ABYSSINIAN MEETING HOUSE  
 PORTLAND, MAINE  
 ROOF TRUSSES

**BENT 4 ROOF TRUSS**

FOR REVIEW -- NOT FOR FABRICATION 6/11/08

**B4-1**

**SK4**

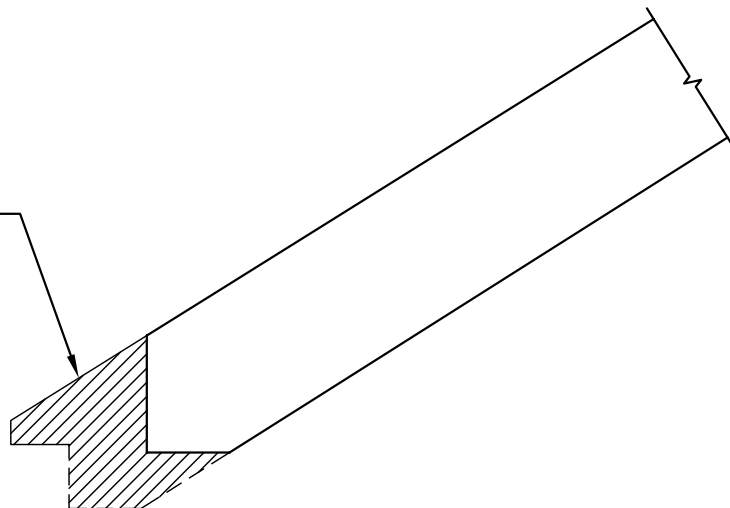
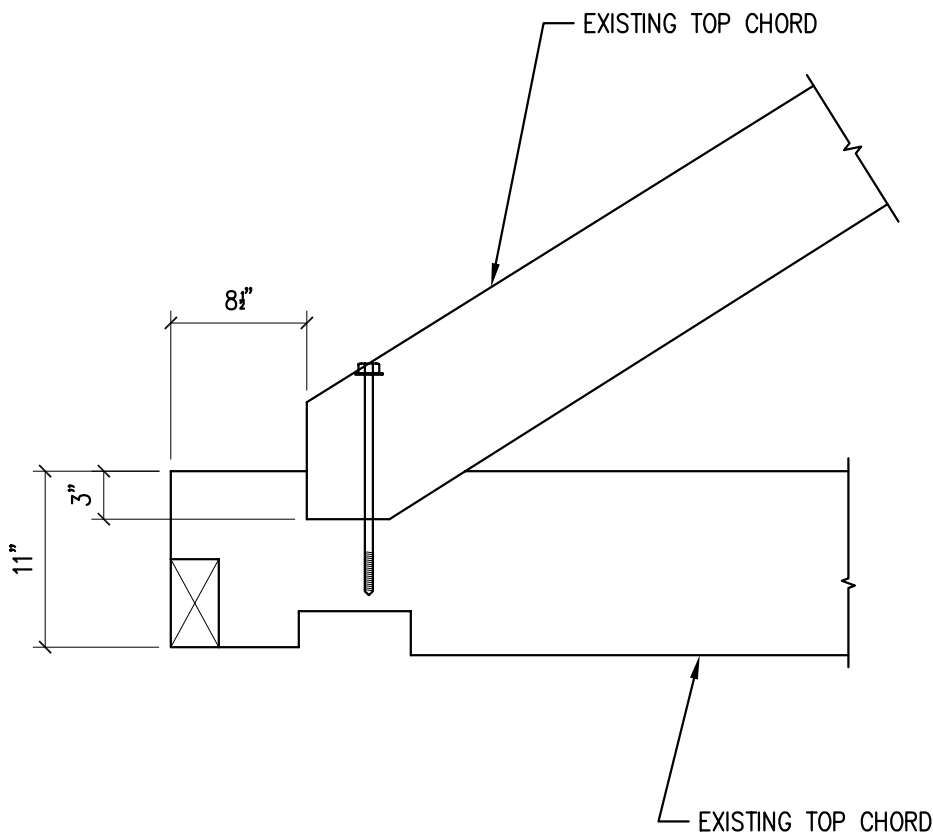
SCOTT --- NEED ABOUT 3/8\"/>
 TO MAKE CALCULATION WORK  
 ACCORDING TO MY NUMBERS.  
 I MAY PROPOSE TWO FULL-WIDTH  
 SHOULDERS THAT ARE EACH 2\"/>
 (I.E. SNAWTOOTH)
